**ANGEL PLACE
LEVEL 8, 123 PITT STREET
SYDNEY NSW 2000**

RESPONSE TO REQUEST FOR INFORMATION - SSD-8571481

This submission of additional information has been prepared by Urbis on behalf of Technical and Further Education (**TAFE**) NSW in respect of the State Significant Development (**SSD**) application (SSD-8571481) for an educational facility at 2-44 O'Connell Street, Kingswood (**the project**).

Swept Path Analysis

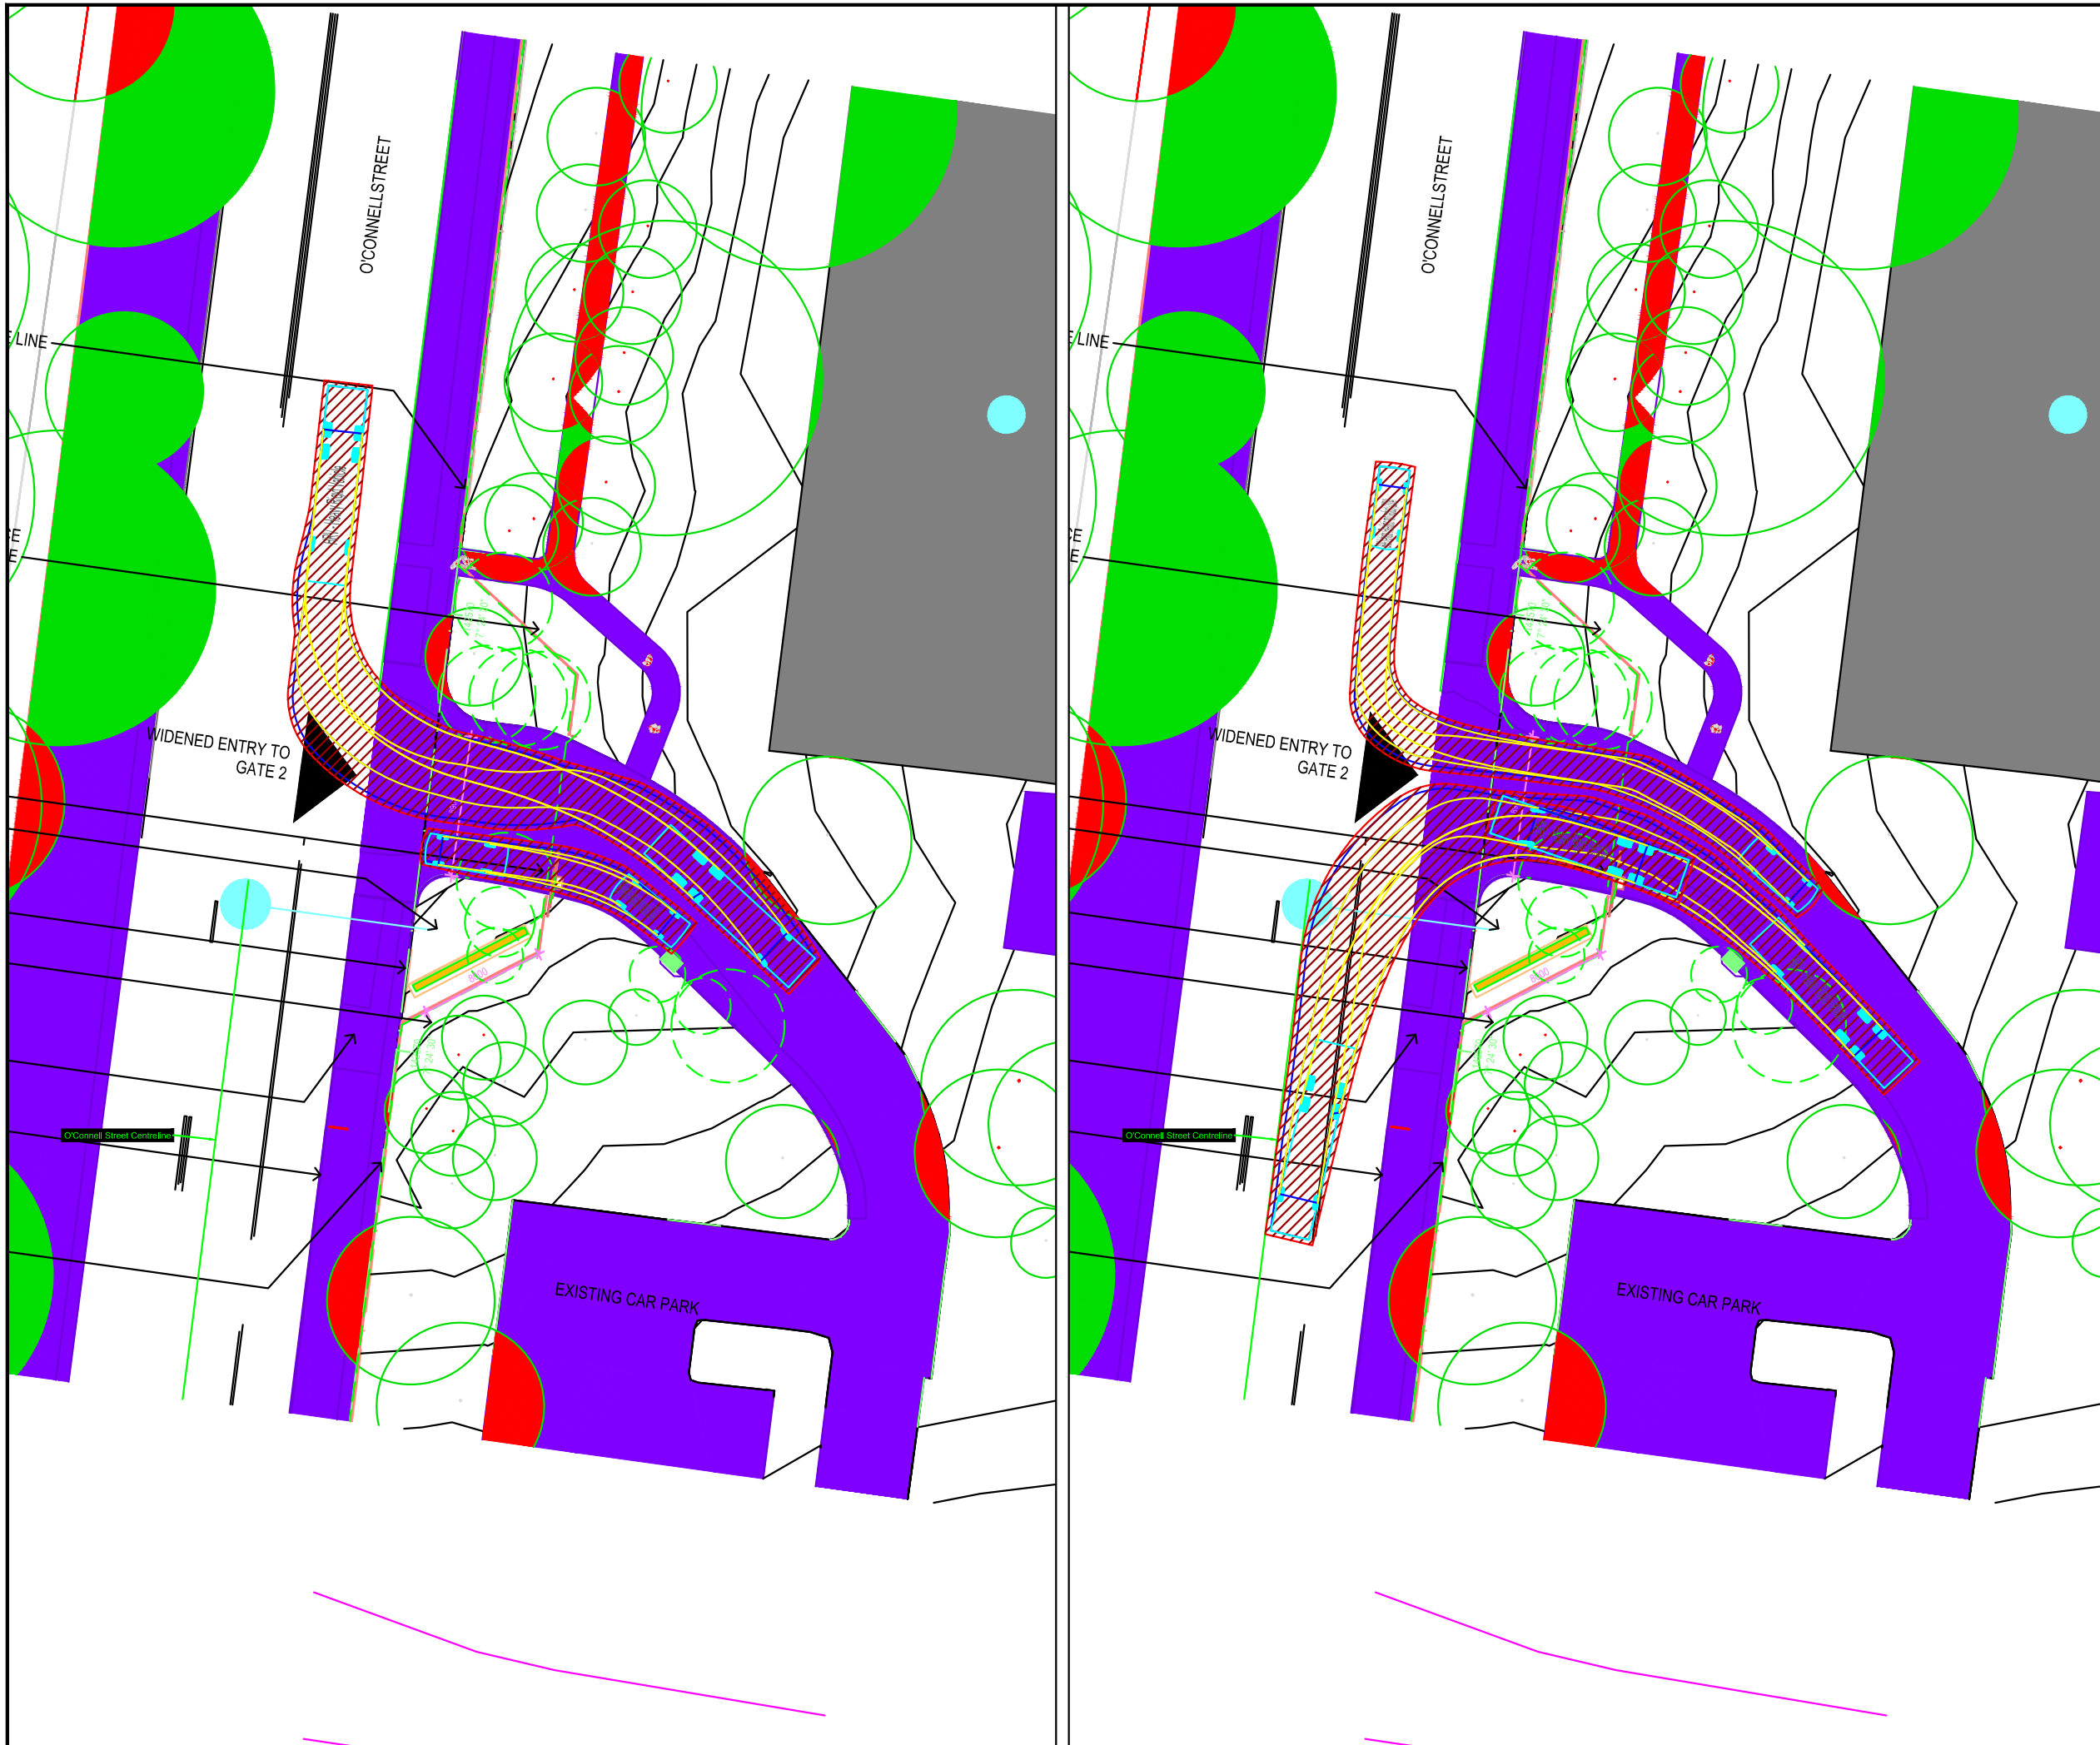
| Item | Agency Comment | Proponent Response |
|------|---|---|
| 12 | <p>Swept Path Analysis</p> <p><i>The swept path movements for a 12.5 metre vehicle at O'Connell Street indicate that simultaneous entry/exit cannot be achieved. This can lead to conflict points at the access where 2 opposing vehicles are attempting to use the access at the same time. It is noted that minor works to remove the median (in driveway) and widening of the internal road are proposed. This could extend to the widening at the entrance of the driveway to allow for simultaneous entry exit.</i></p> <p><i>Recommendations are as follows:</i></p> <p><i>The design of the access point should be widened to allow for simultaneous entry/exit movements of the largest vehicle with a passenger vehicle.</i></p> <p><i>However, as O'Connell Street is a Local Road, Council is to determine if the development risks raised by TfNSW is satisfactorily addressed by the applicant. Should the driveway be widened the swept path of the longest vehicle entering and exiting the subject site, shall be in accordance with AUSTRROADS and to the satisfaction of Council</i></p> | <ul style="list-style-type: none"> ▪ As discussed in Section 2.1.2, it is proposed to increase the access point by 1m from 7.9m to provide a total width of 8.9m. ▪ The amended access driveway has been designed in accordance with AS2890.1 (2004) and AS2890.2 (2018), as Austroads Guidelines are not applicable due to the driveway's location on private land. ▪ As illustrated in the revised swept paths appended to the Traffic Impact Assessment (Attachment D), the widened driveway will accommodate the largest size vehicle (12.5m heavy rigid vehicle) passing a B99 design vehicle at the site boundary. |

In response to concerns raised regarding the adequacy of the western access point on O'Connell Street, it is proposed to seek consent for an increase to the width of the driveway access point as illustrated in the revised Architectural Plans (**Attachment B**). It is proposed to increase the access point by 1m to increase the existing width from 7.9m to a total width of 8.9m. The amended access driveway has been designed in accordance with AS2890.1 (2004) and AS2890.2 (2018), as Austroads Guidelines are not applicable due to the driveway's location on private land. The amendments will require tree removal, as discussed further in **Section 2.2**.

As illustrated in the revised swept paths appended to the Traffic Impact Assessment (**Attachment D**), the widened driveway will accommodate the largest size vehicle (12.5m heavy rigid vehicle) passing a B99 design vehicle at the site boundary. It is noted this scenario will not be frequent, as heavy rigid vehicles are only anticipated to access the site once every 2 weeks, arriving and departing outside of peak times. It is further noted the results of SIDRA modelling indicate the access driveway will operate at a Level of Service A, and that there will be no impact on the sight distances as a result of the
